# CITY OF ALBUQUERQUE

**Re: Indian Cycle Dealer, Grading and Drainage Plan  
Engineer's Stamp Date 8-13-14 (C17D002A22)**

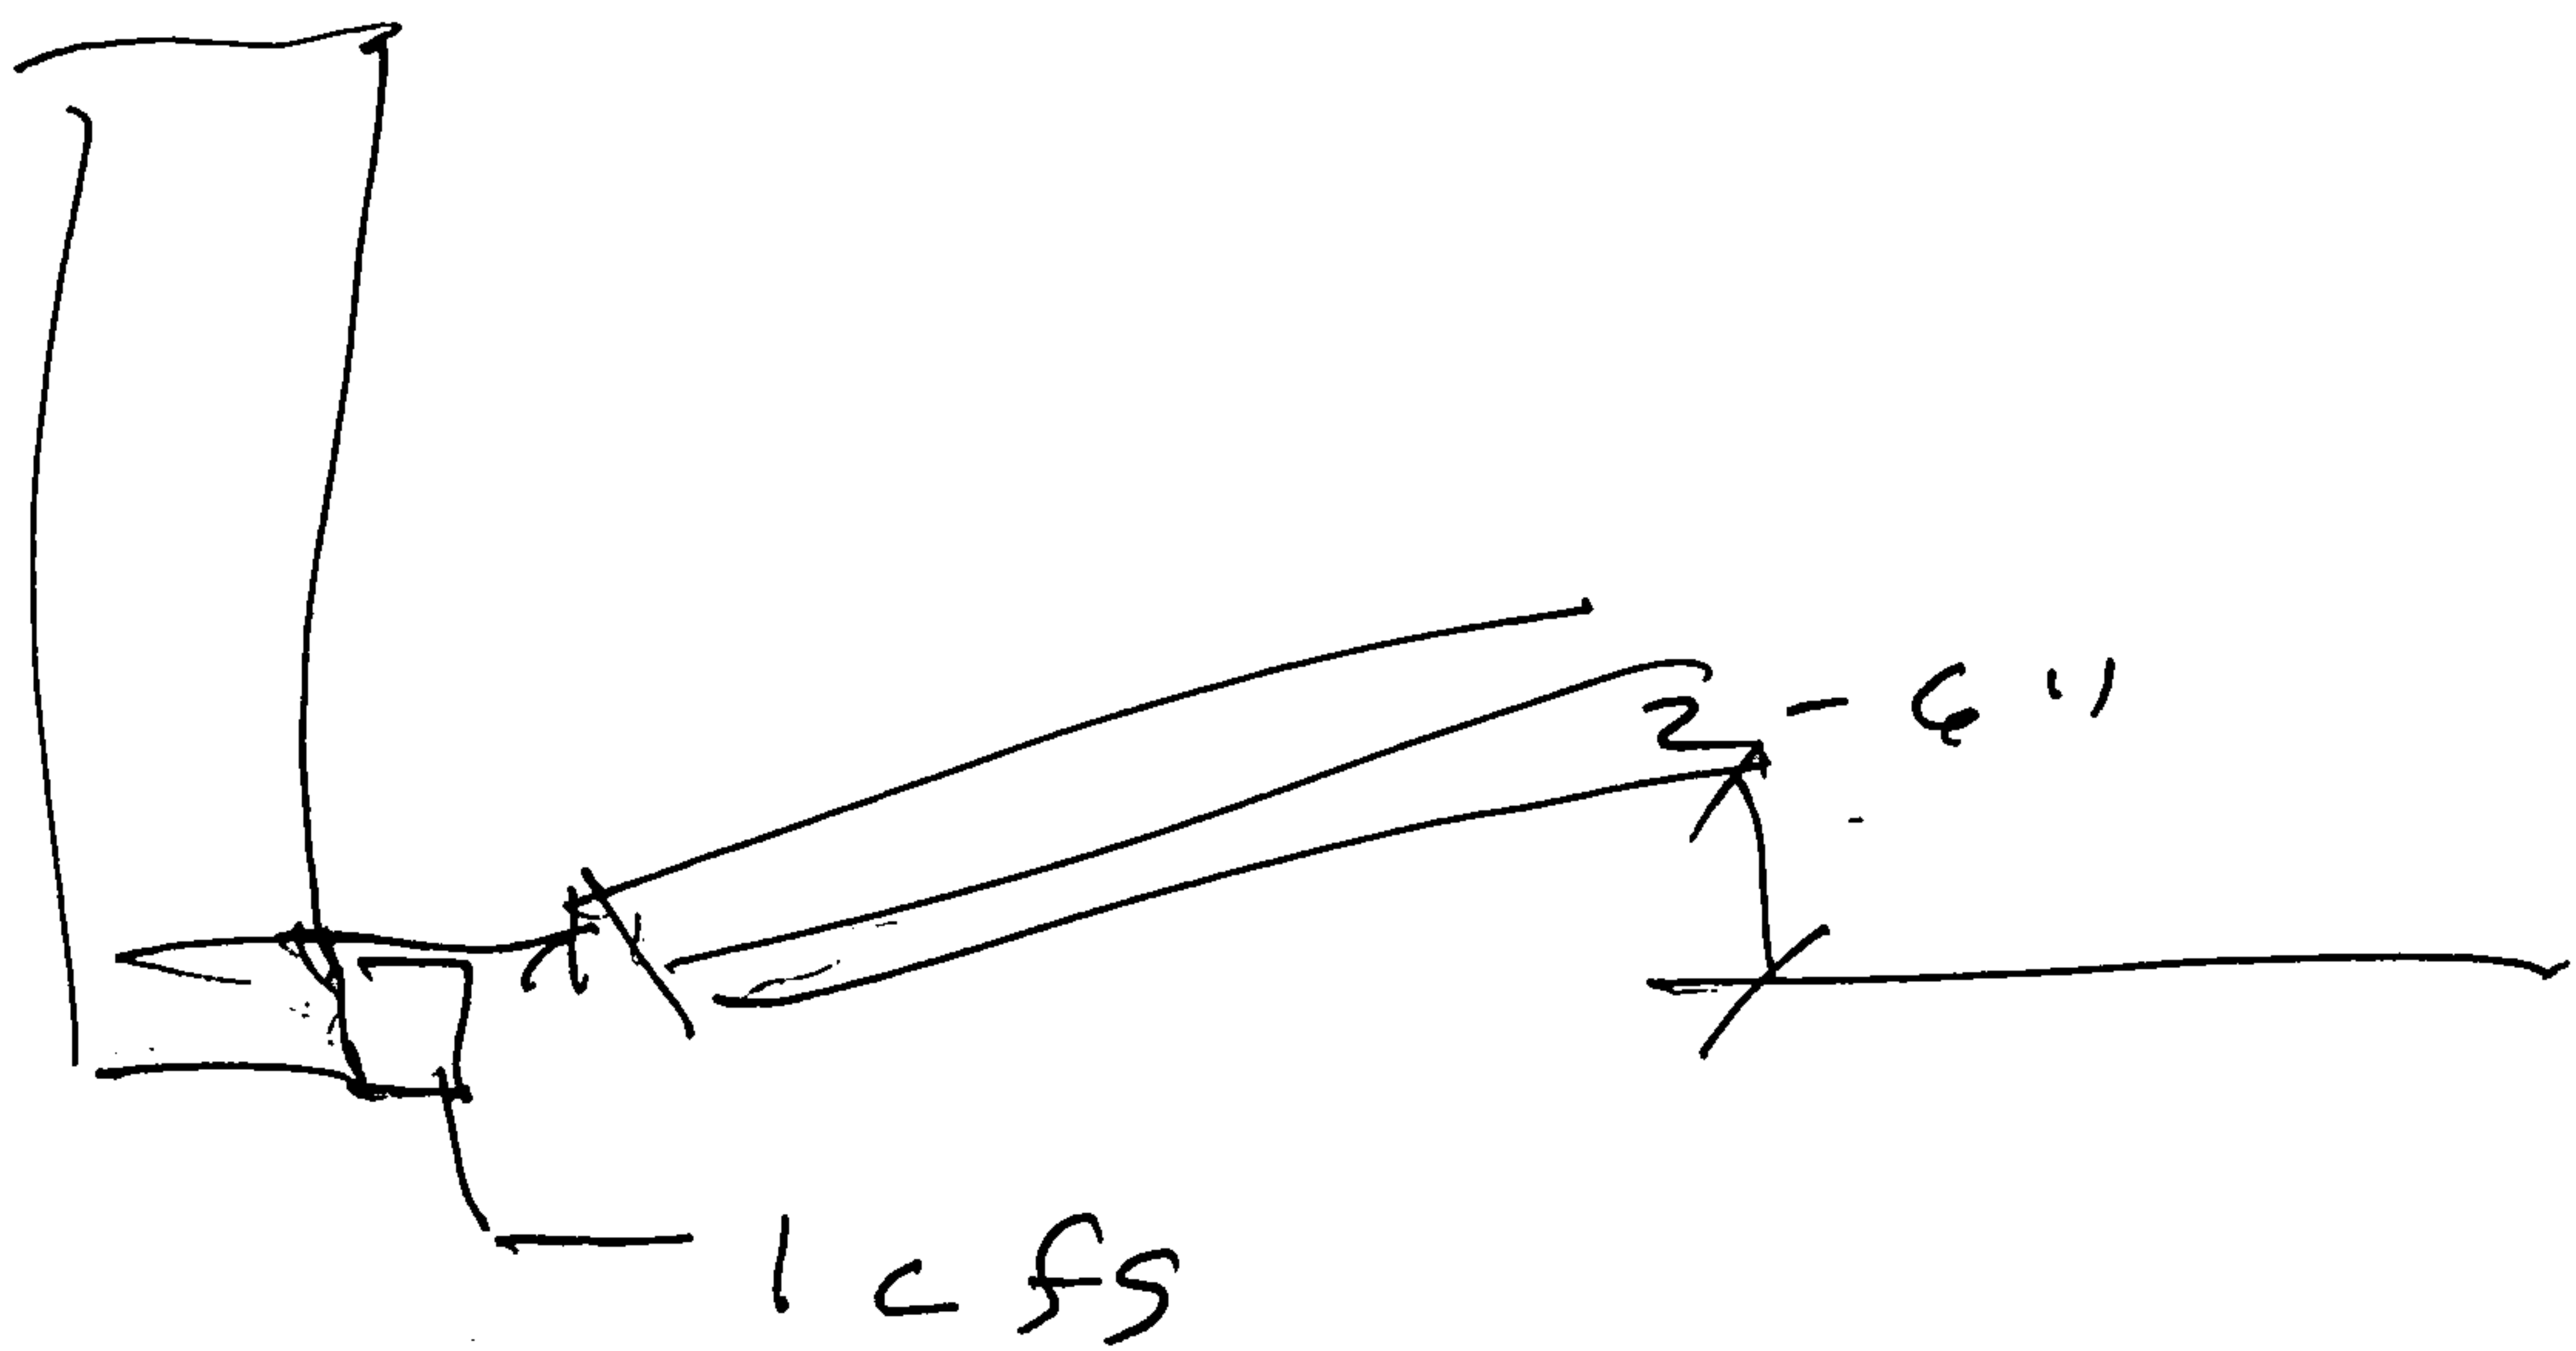
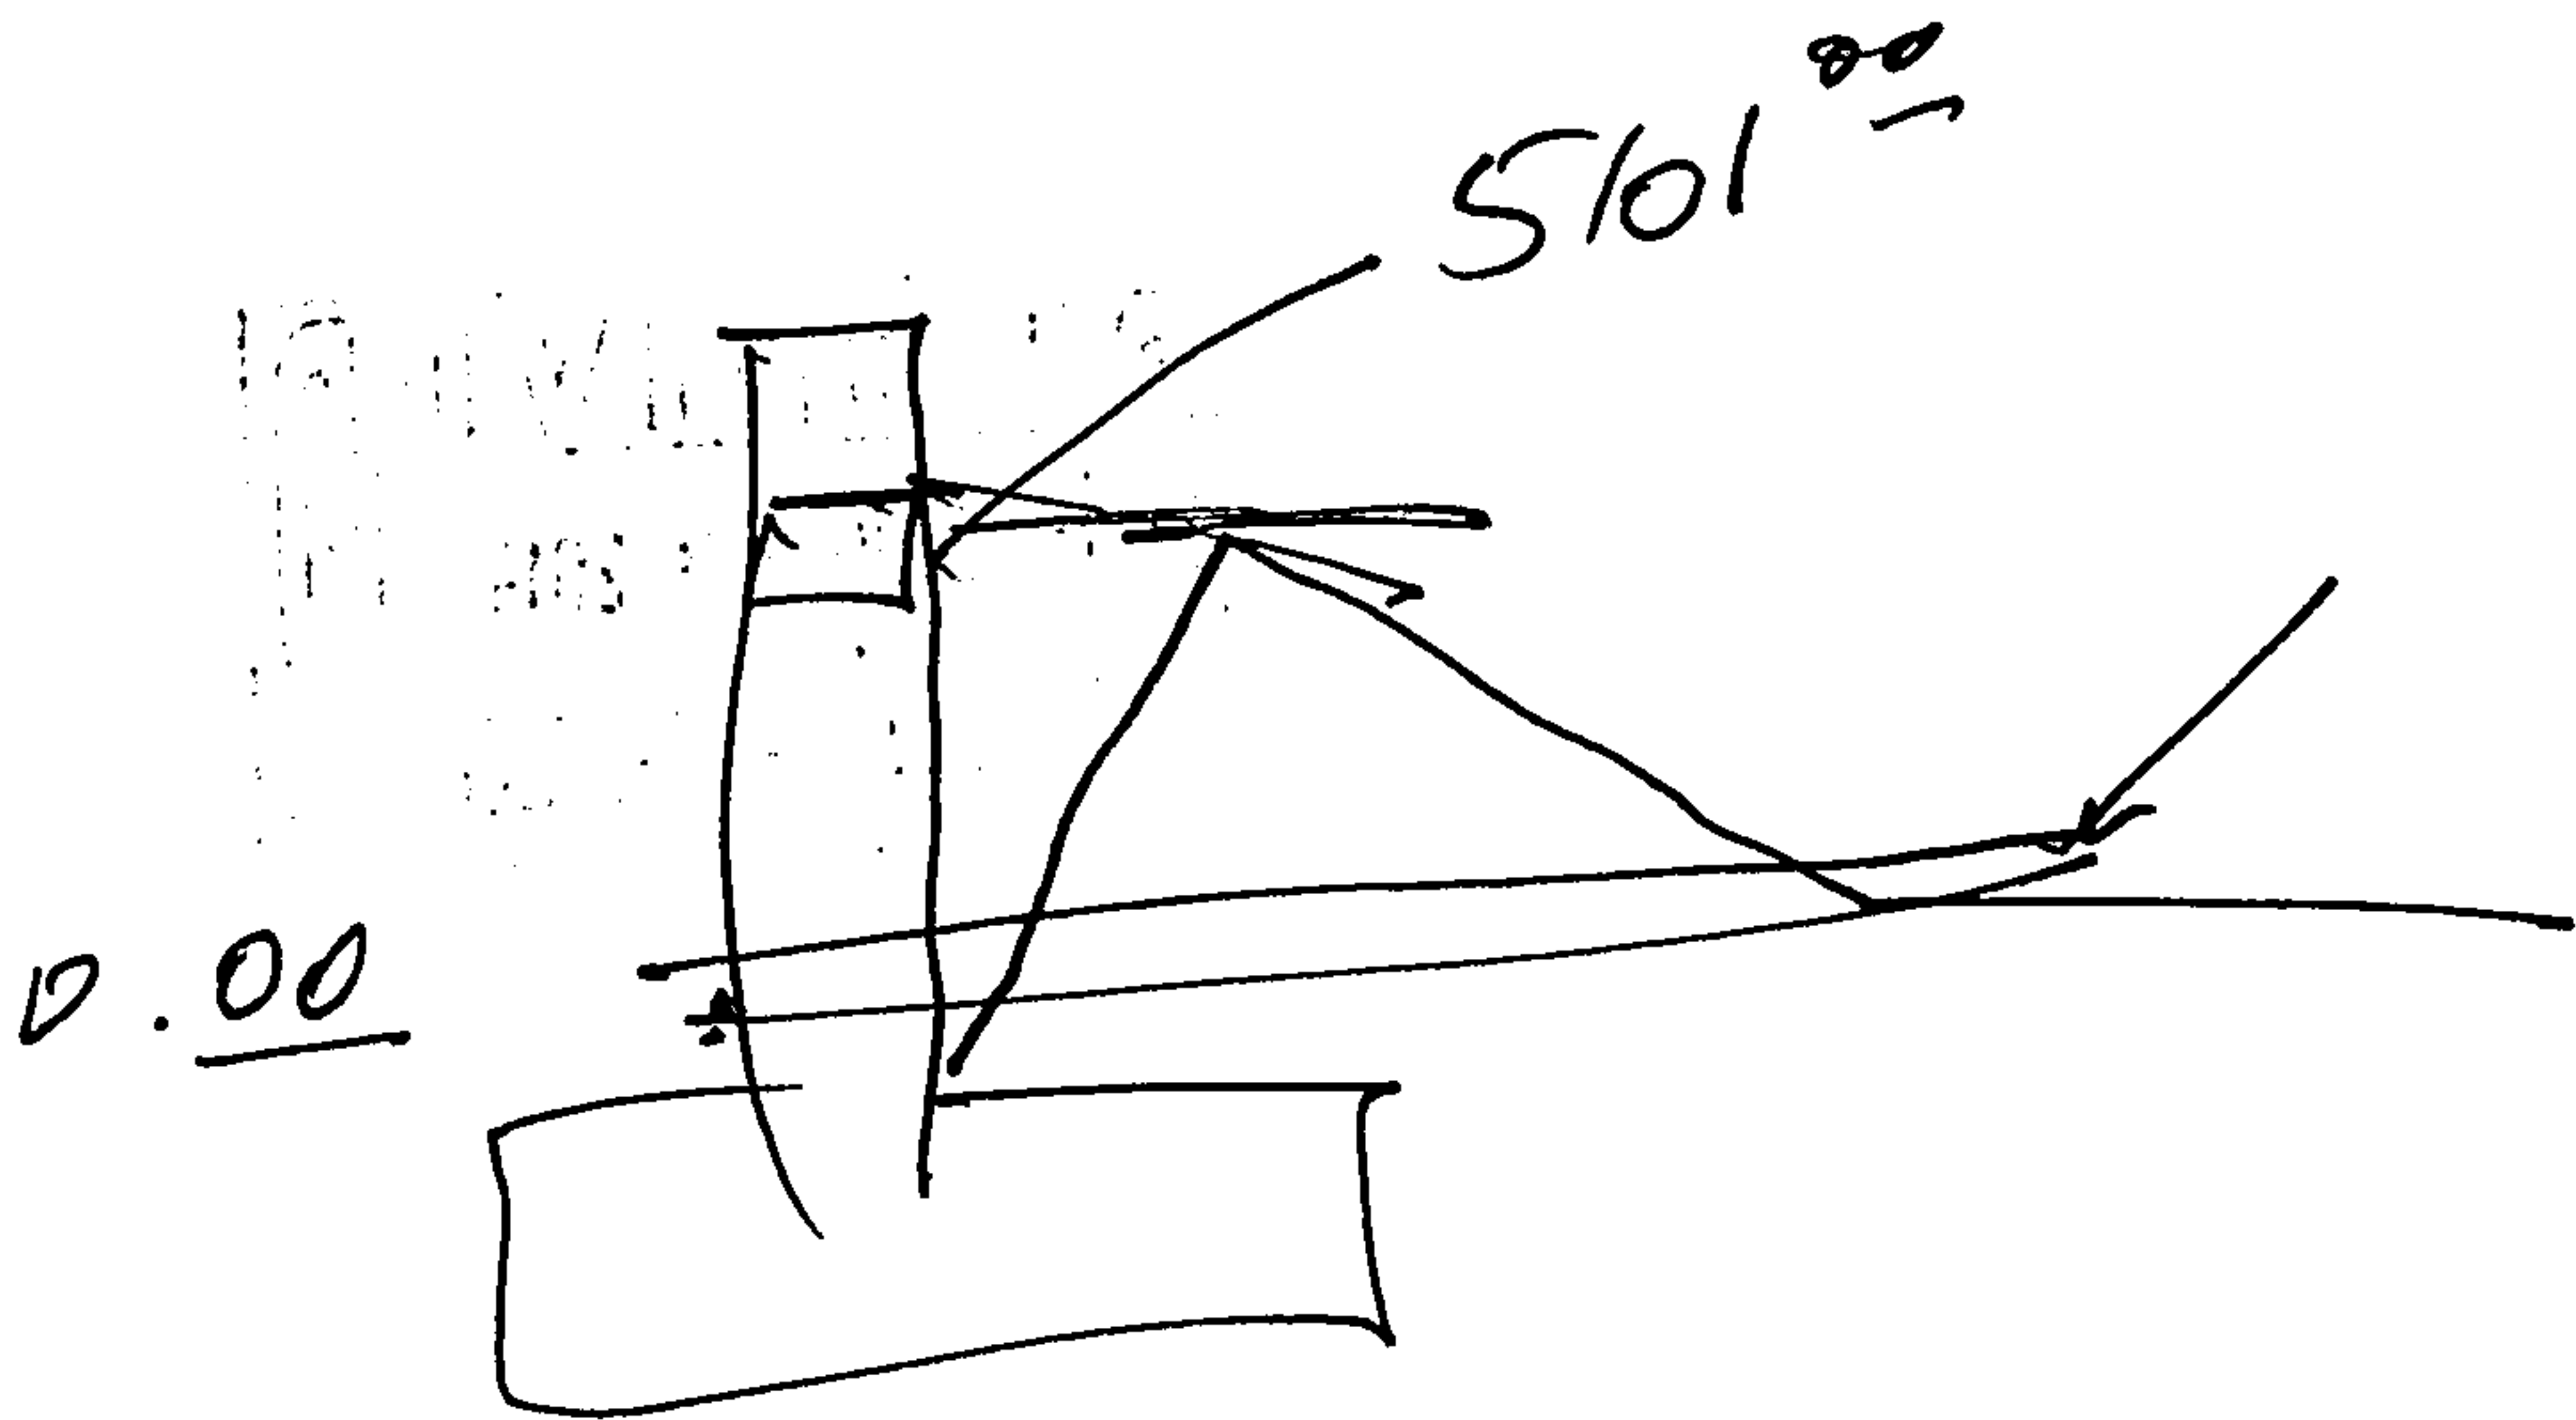
1. The 6 inch pipes are to extend through the CMU wall and the openings around the pipes grouted.
2. The grade of the dirt at the northwest corner of the pond is to be at or above the water surface elevation (01) and two blocks are to be removed from the wall at the 01 or top of dirt elevation for an emergency spillway.
